Development Facilitation Team (DFT) – Review Comments

Project No: PR-2021-005151 Date: 08/09/2023 Agenda Item: #1 & 2 Zone Atlas Page: A-12

Legal Description: TRACT D-1 PLAT OF TRACTS D-1, E-1, AMAFCA BLACK ARROYO CHANNEL ROW PARADISE HEIGHTS

Application For: SD-2023-00124-PRELIMINARY PLAT (DHO)

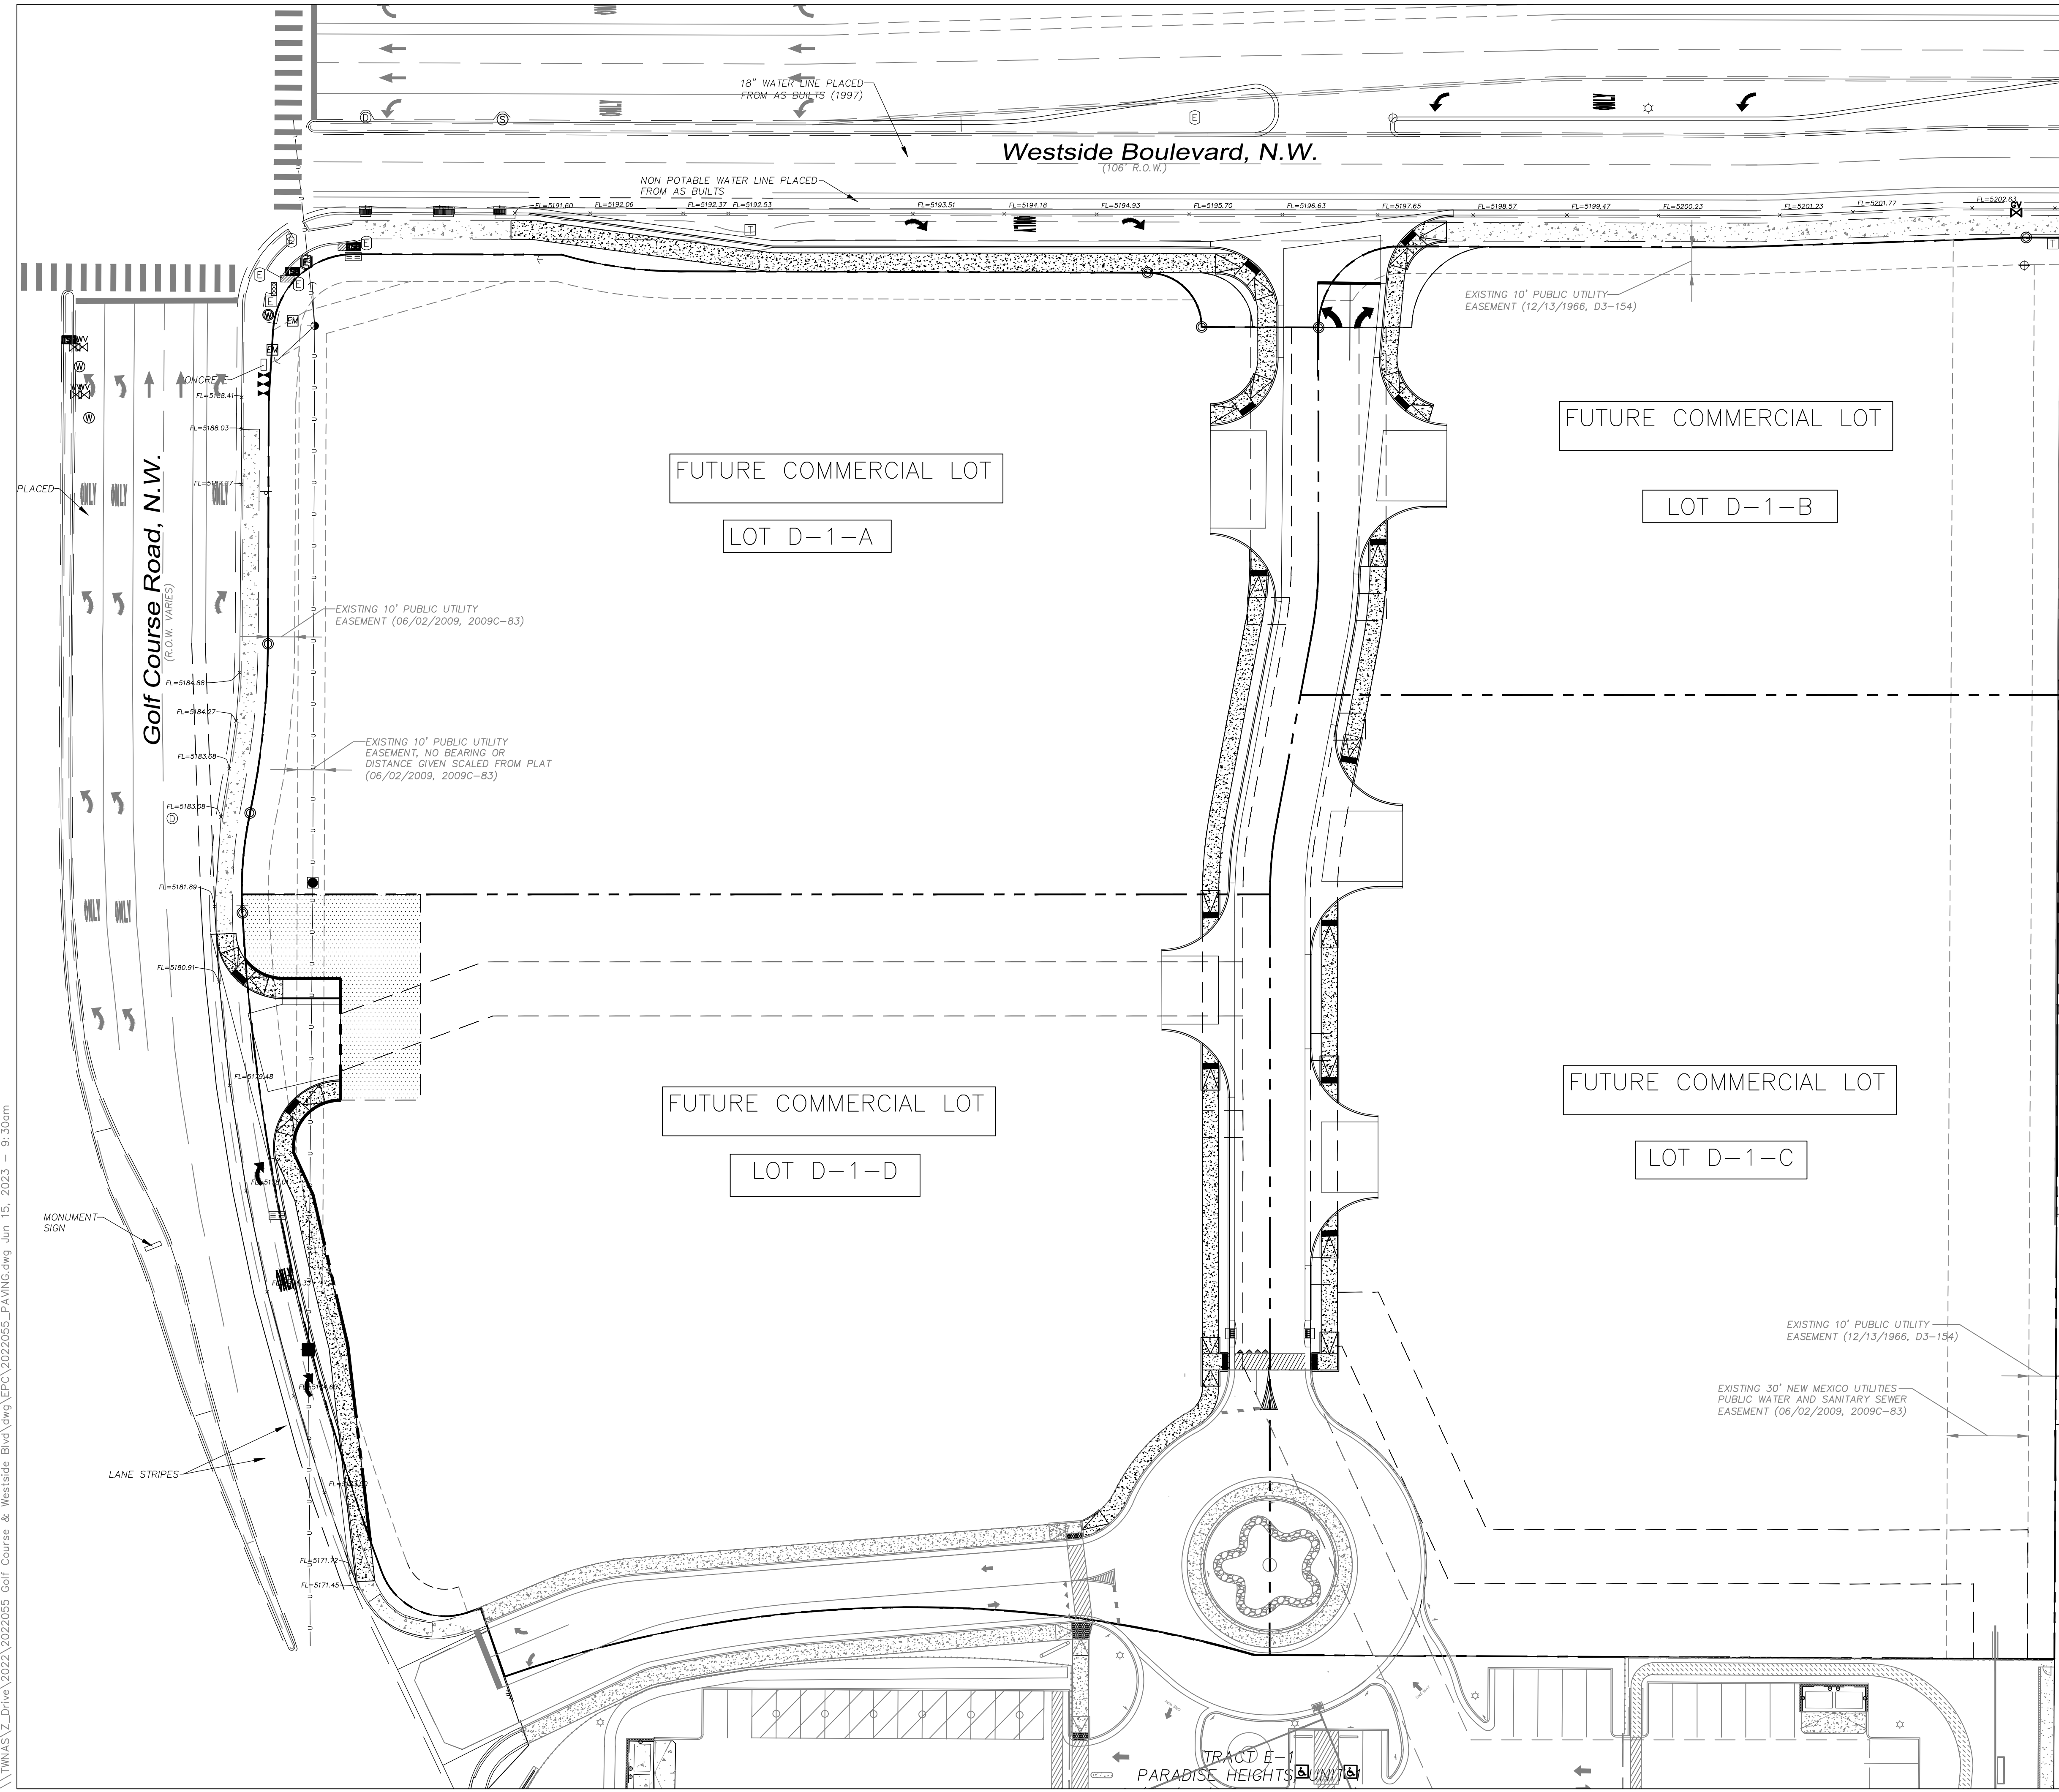
- ***Please confirm the compliance with section 7 of the DPM Table 7.2.29 regarding Sidewalk width requirements and its landscape buffer.**
-Standards and Requirements per Transportation-
Property not within a Center or Corridor area.

- Westside Boulevard NW is a Principal Arterial Roadway. A 6 ft sidewalk and 5-6 ft landscape buffer is the requirement.
 - Golf Course Road NW is a Minor Arterial Roadway. A 6 ft sidewalk and 5-6 ft landscape buffer is the requirement.**Update 8/7/23: Staff notes that while the sidewalks and buffers are included in the associated Infrastructure List, a Sidewalk Exhibit is requested depicting the sidewalks and buffers. The exhibit should include any changes to the cross section if it changes along Golf Course or Westside Blvd.**

- Sheet C1 of the Plat depicts future commercial development on the four proposed lots. Please confirm future development on the four proposed lots (if known).
